# Proposed Garage removal and erection of new at, The Cottage, Low Street Site Location : North Wheatley, Retford, DN22 9DR.

## Policy Counter Statement – June 2023

In support of the erection of a new garage.

Drawing Title:  
PROPOSED PLANS AND ELEVATIONS

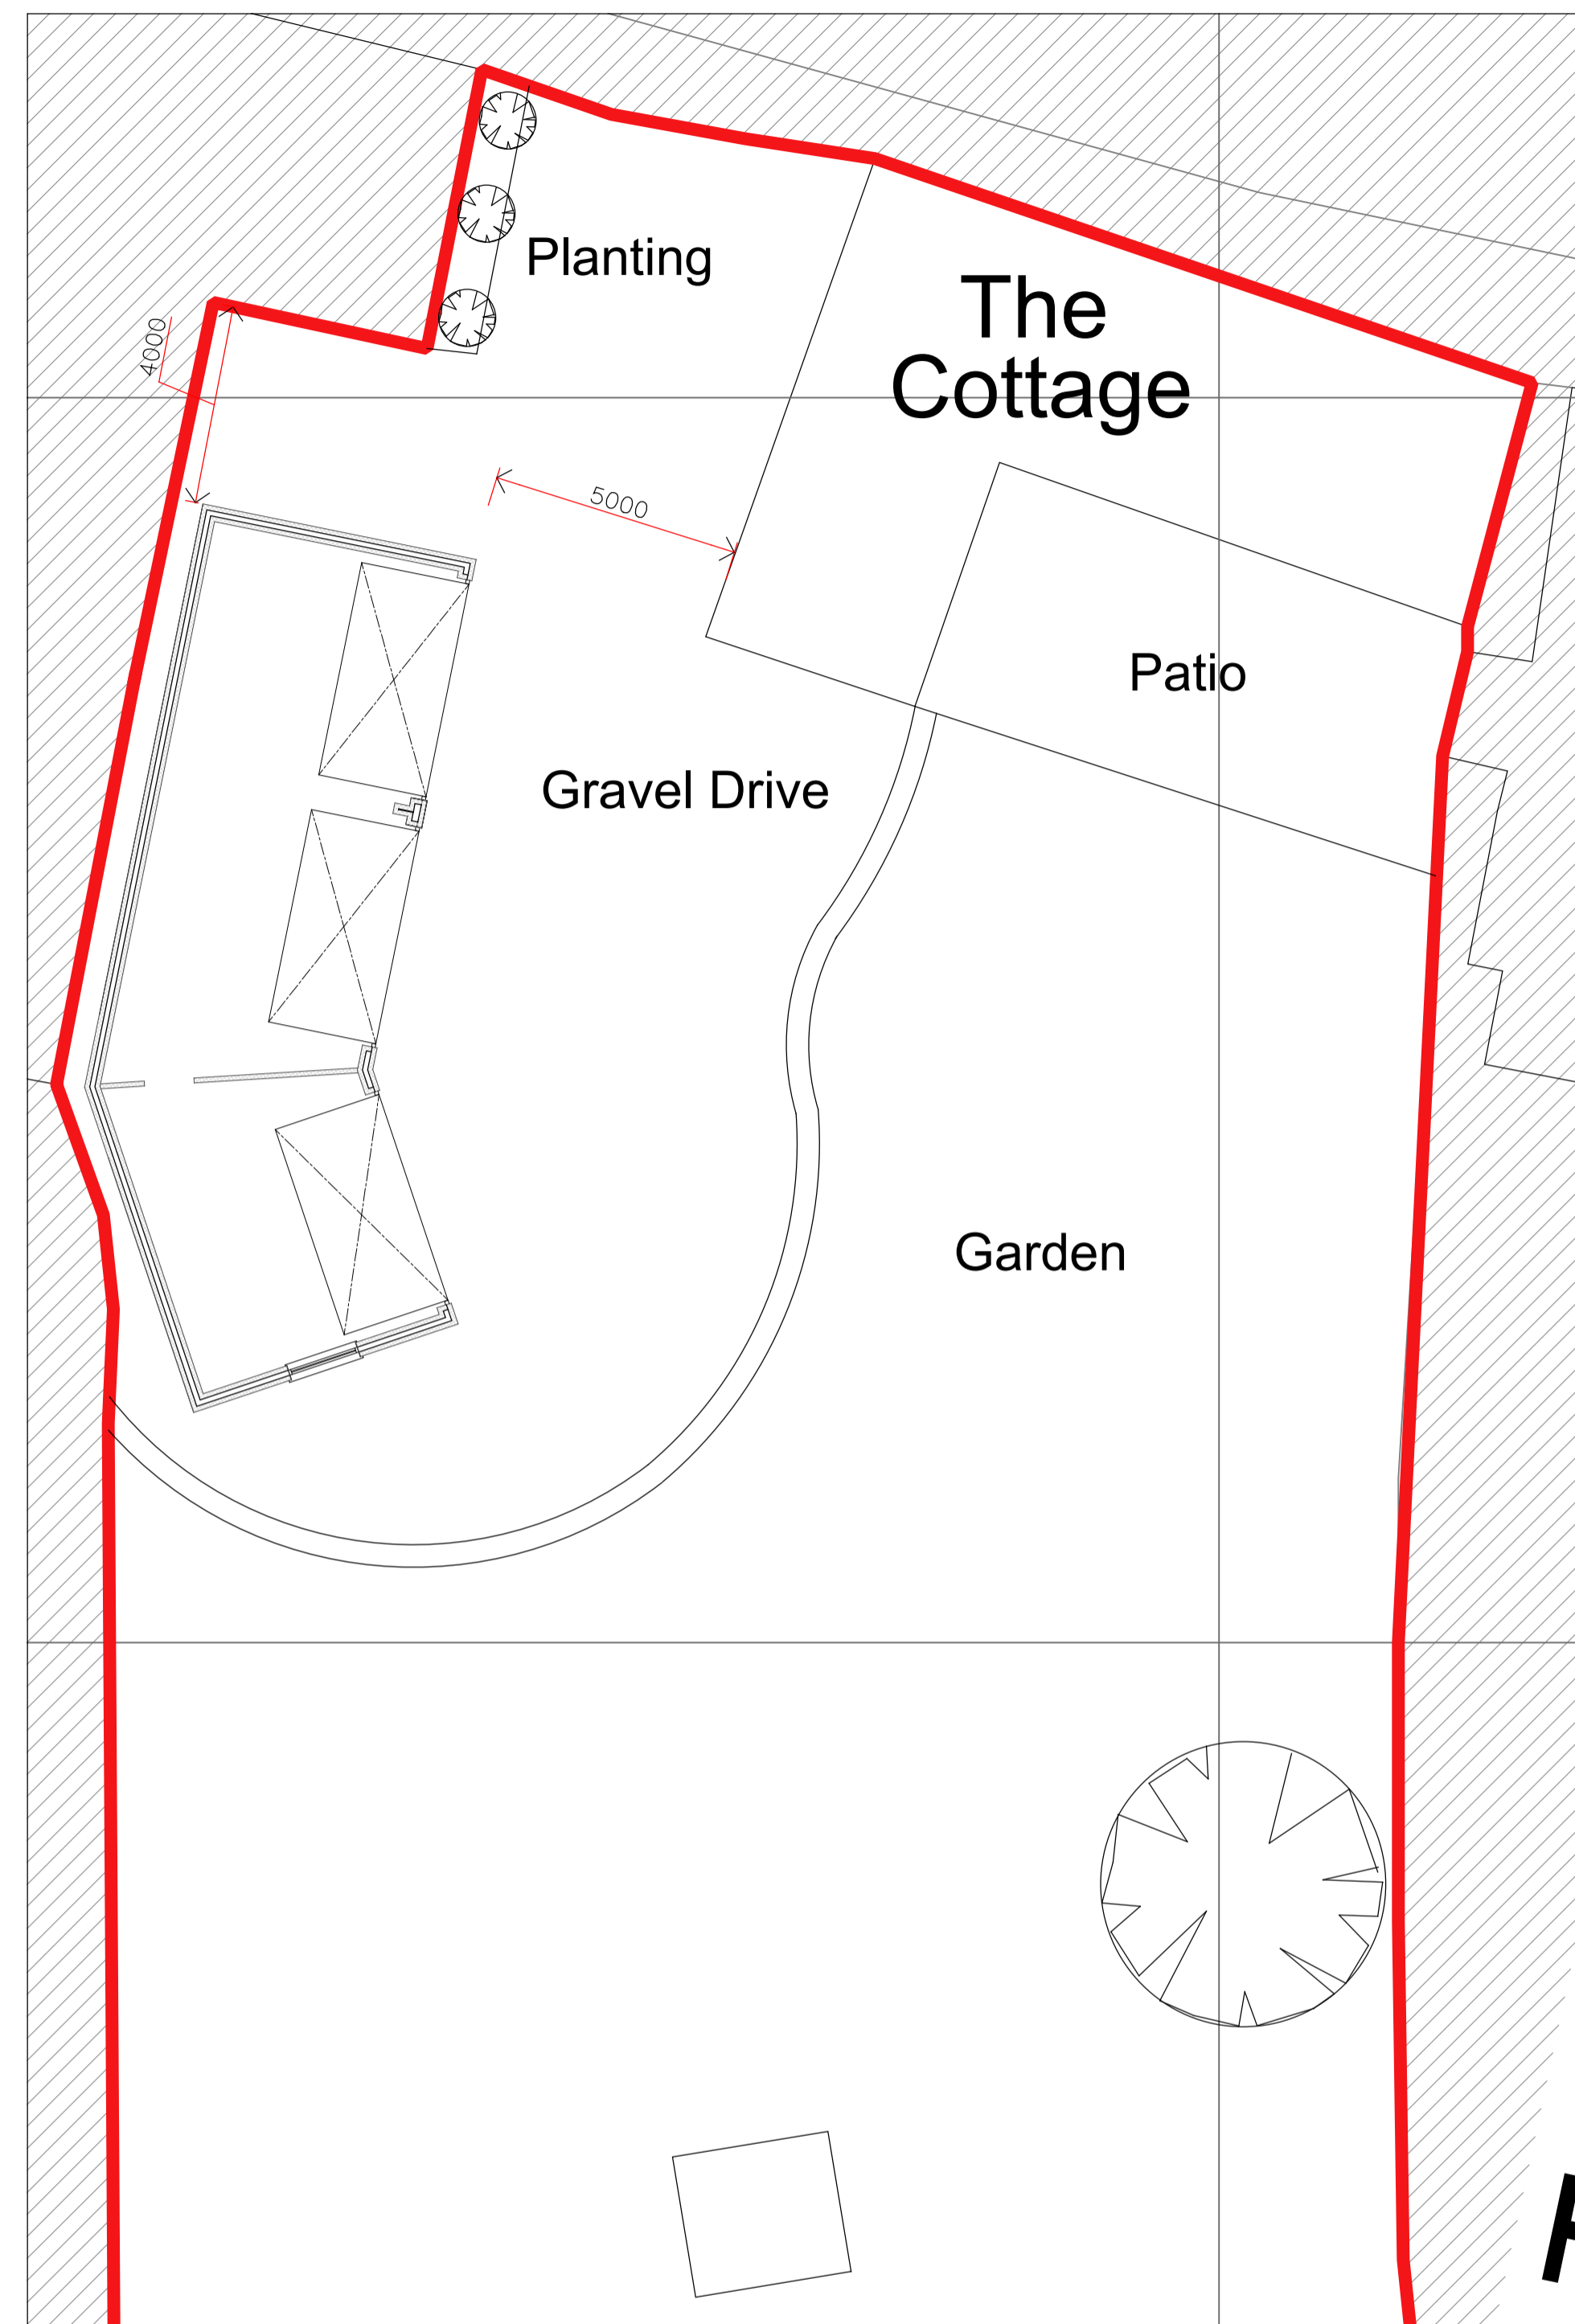
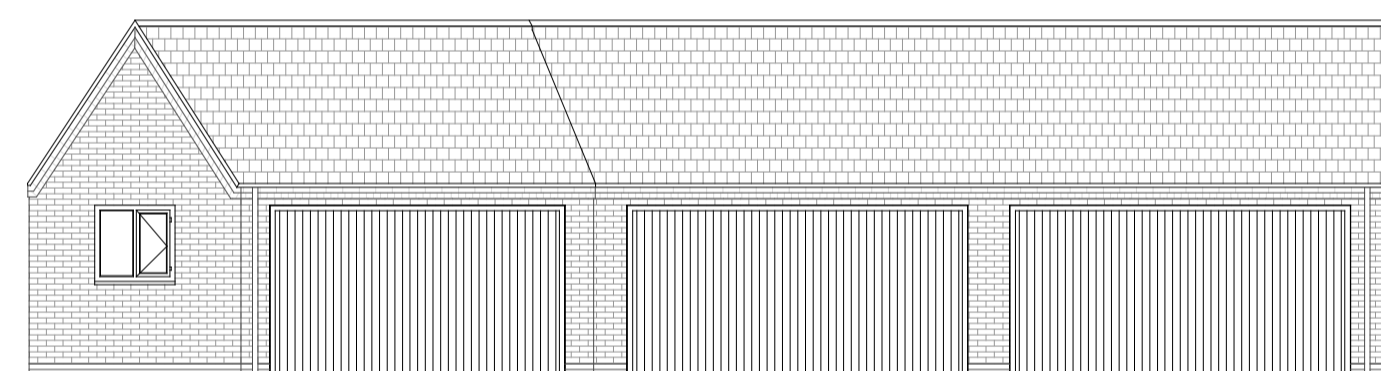
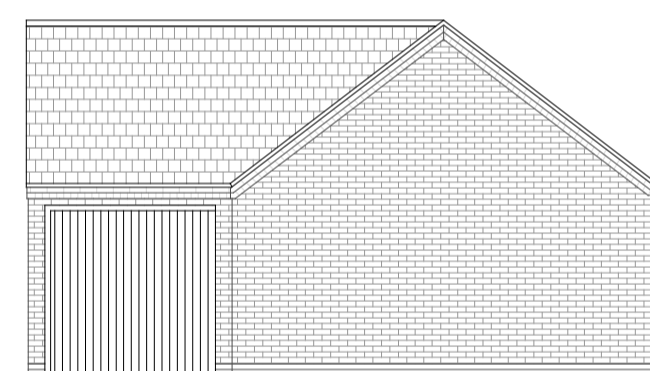
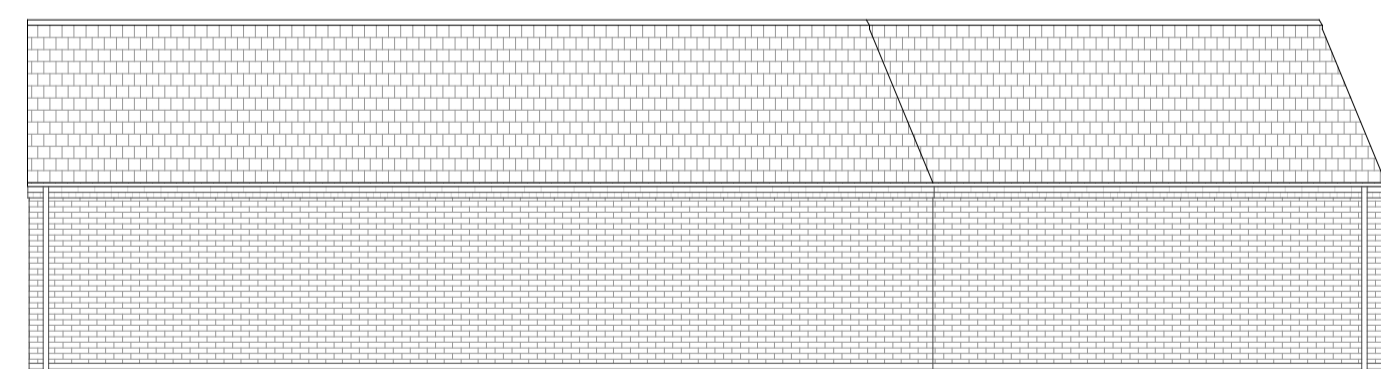
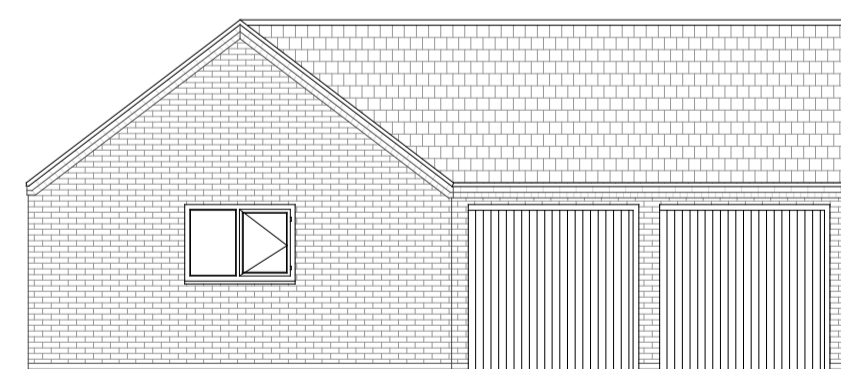
1. White render
2. Roof pitch / height
3. Garage door material.

*The proposed garage, by virtue of its scale, position and proximity to the adjacent dwelling, 'The Barn', would have an unacceptable overshadowing and overbearing impact to the first floor south facing window of a habitable room within this neighbouring dwelling. This would unacceptably impose on the enjoyment of that dwelling for existing and future occupiers. The proposal is therefore contrary to Policy DM4 and the guidance within the NPPF.*

The position of the new garage was considered carefully, the intention was to site the proposed garage 3000mm away from the window / wall to The Barn, as mentioned in the refusal. However, as a compromise we have now increased this to 4000mm which reduces even further any impact the proposed garage may have onto the neighbouring property.

It also worth mentioning that the roof original roof pitch was kept lower originally as it softens the overall mass off the garage. But we were requested to adjust this pitch by the conservation officer as mentioned above. This request and adjustment lifted the ridge height by circa 600mm.

In response the conservation officers comments the design was updated to change the white render to a facing brick, and a Carlton Clayburn Civic was selected due to its heritage appearance. And architectural dentil course was added to the wall and gable heads. The roof pitch was adjusted from 30 degrees to 40 degrees. And additional information provided and the proposed.
